KITITITAS COUNTY

DEPARTMENT OF PUBLIC WORKS

TO: All Staff
FROM: Public Works Planning Review Team
DATE: 8/26/2020
SUBJECT: BL-20-00020 Teanaway Ridge

The Public Works Department has reviewed the Request for Boundary Line Adjustment Application. In order to ensure that it meets current Kittitas County Road Standards, the applicant needs to provide the following prior to final approval:

# RECORD OF SURVEY

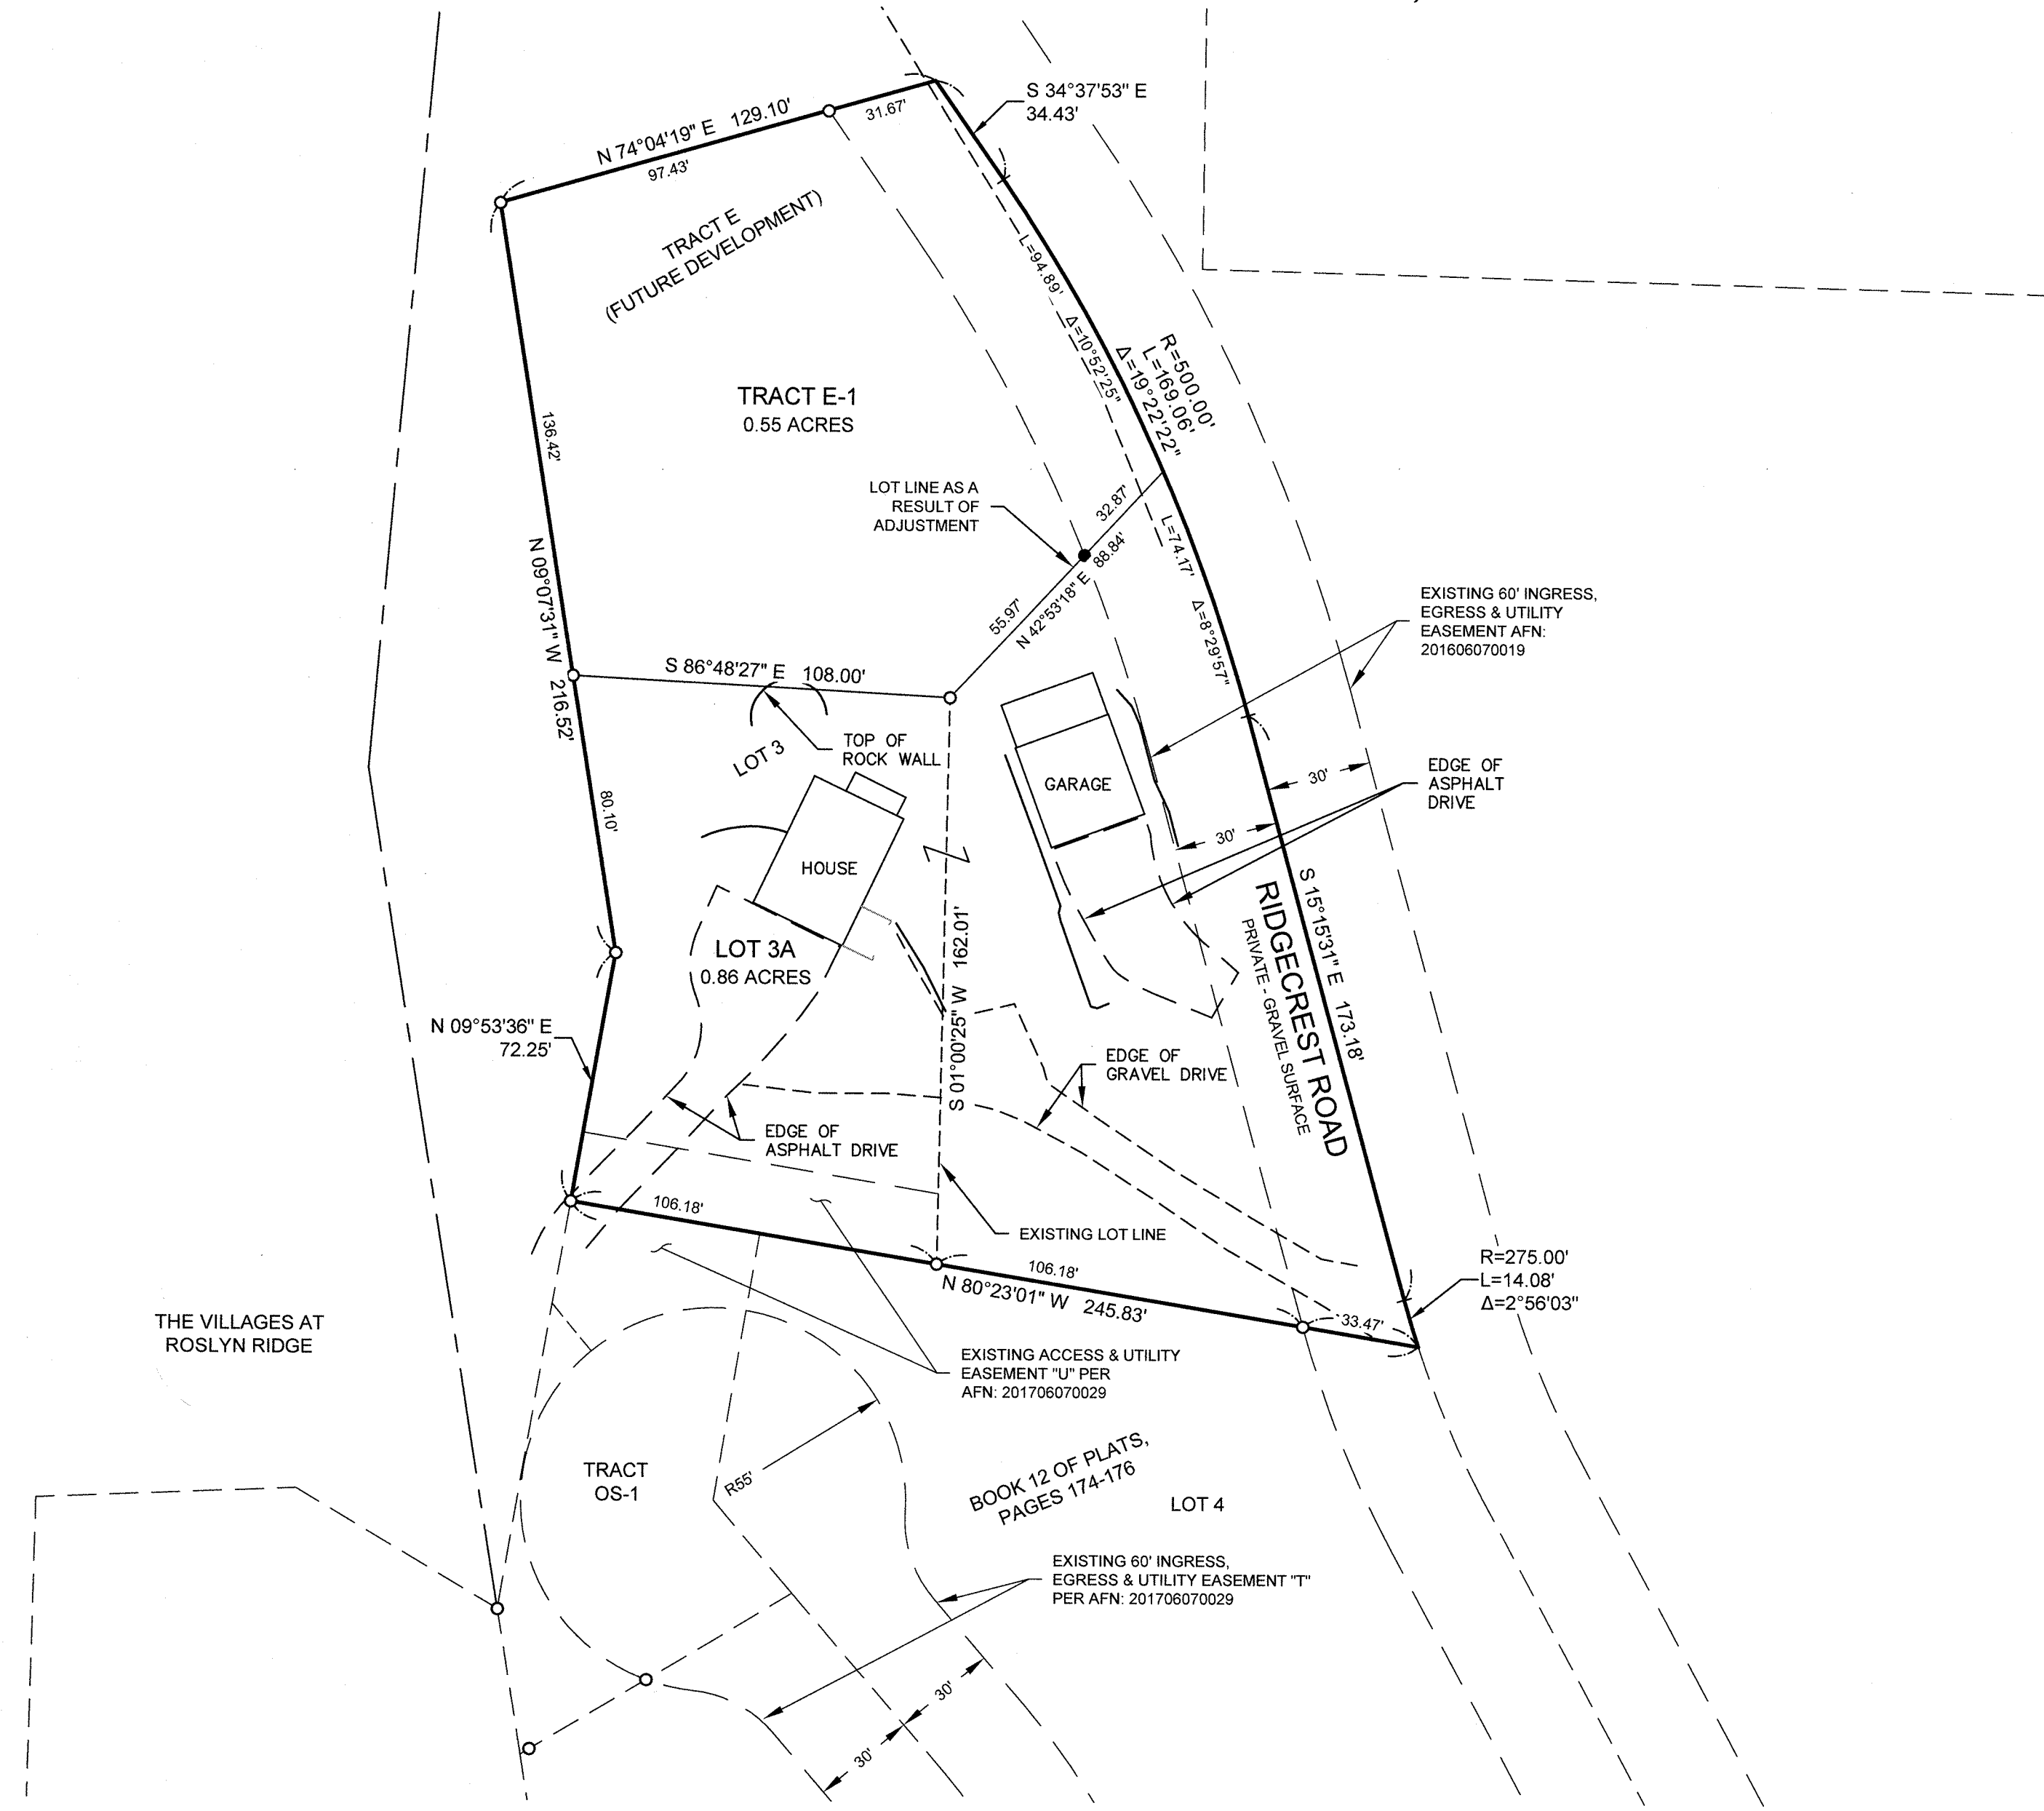
1. A revised legal description that describes the final configuration of the subject property shall be required.
2. A survey map for review
3. Show access easements on the face of the BLA

As the application does not include a survey map, any comments will be reserved until final.
